1
A-1.1
PROPOSED NEW PLAN
Scale: 1/4"=1'-0"

1 PROPOSED NEW PLAN
 A-1.1
 Scale: 1/4"=1'-0"

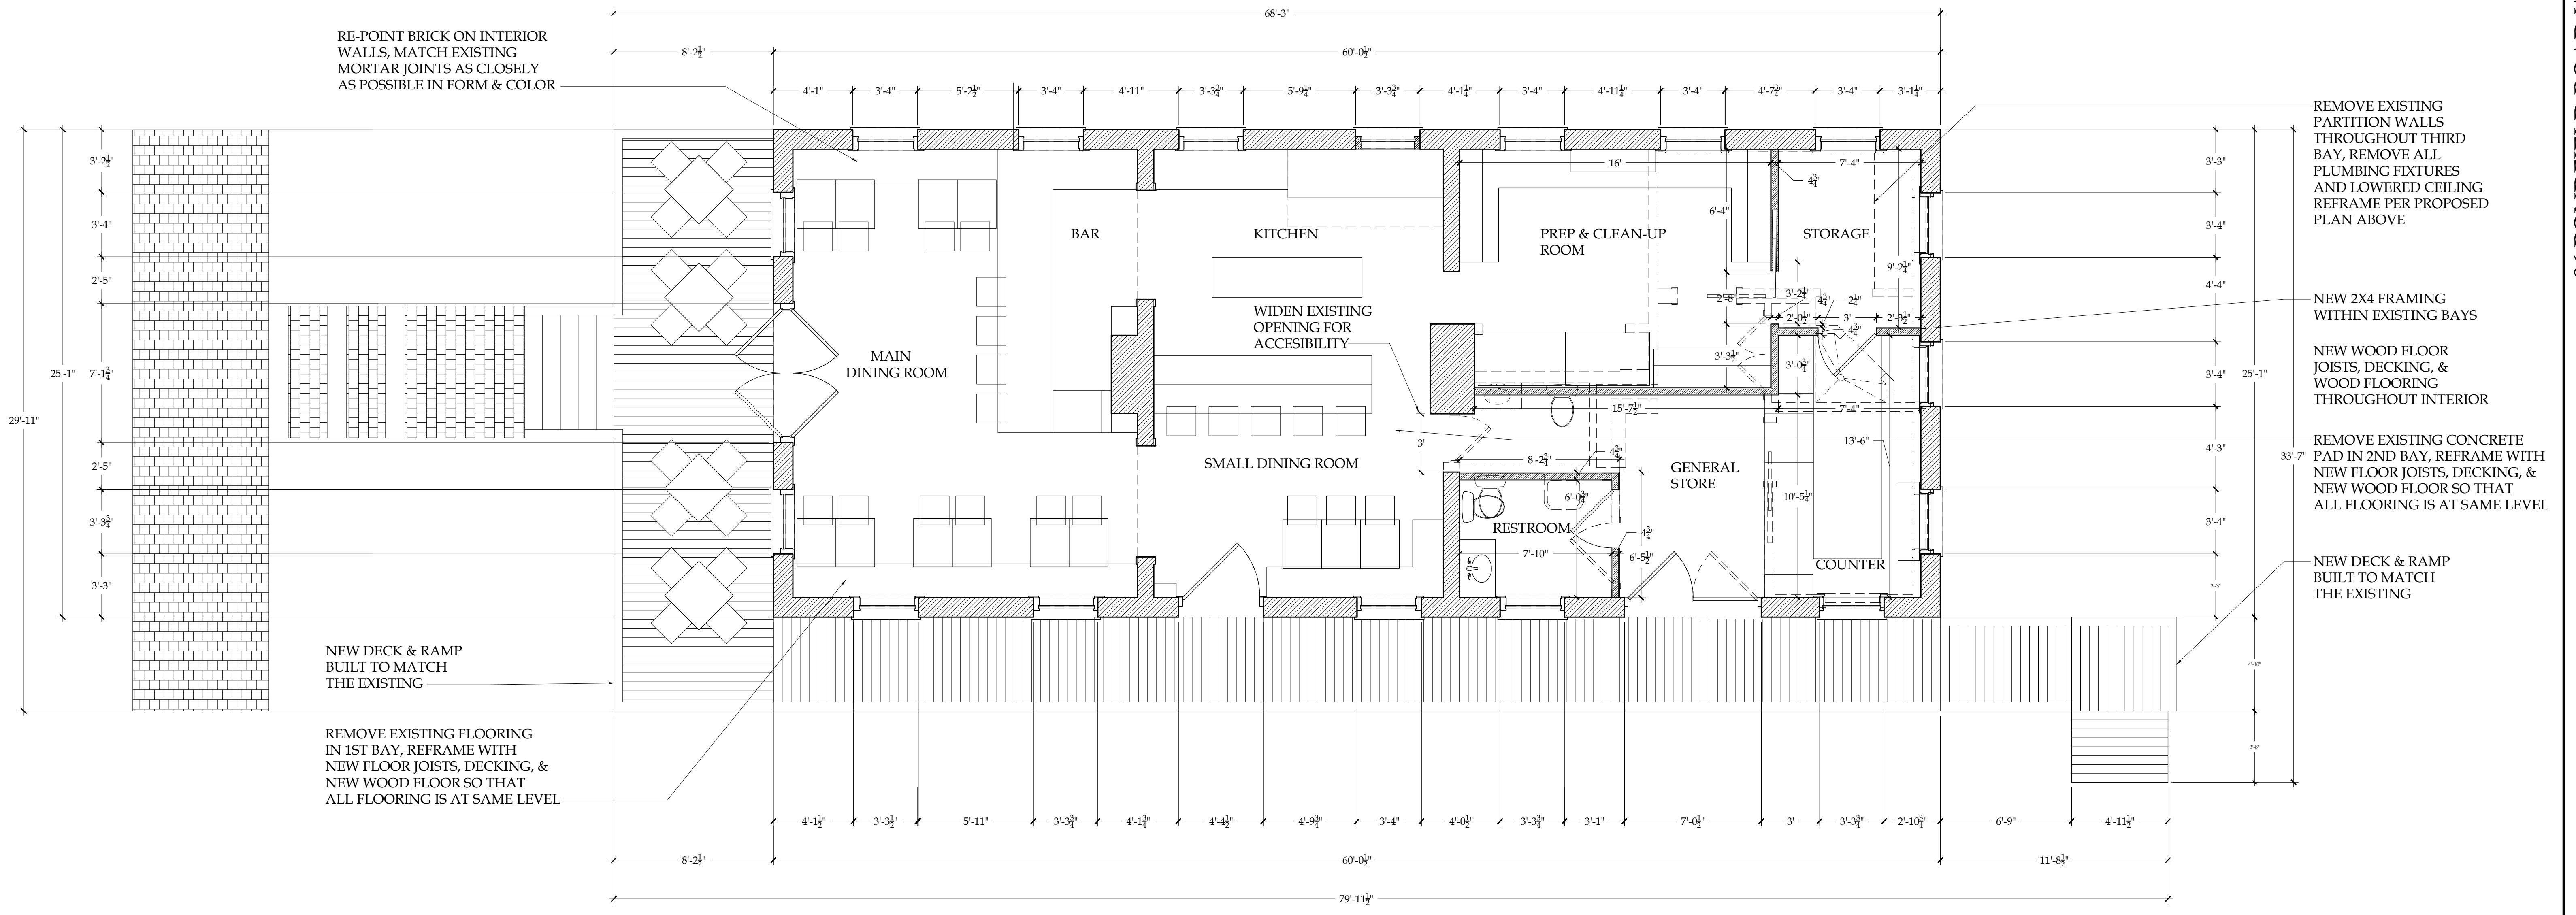
Please show stairs compliant with IBC Section 1009.

Please show handrails and guards compliant with IBC Sections 1012 and 1013.

Please show new door size.

Please provide any outdoor dining occupant loads as per IBC Section 1004. NOTE: If total occupant load exceeds 40, two toilet rooms will need to be provided.

Please show ramp/deck elevations with dimensions. Show ramp, guards, handrails and edge protection details for building code and ADA compliance.

Please provide structural plans, sections and details stamped by a design professional including (but not limited to) the following:
1. Extent and details of any concrete and/or masonry work.
2. All new framing (girders, beams, headers, joists, posts, studs, etc.) with sizes, spacing, spans and connection details.
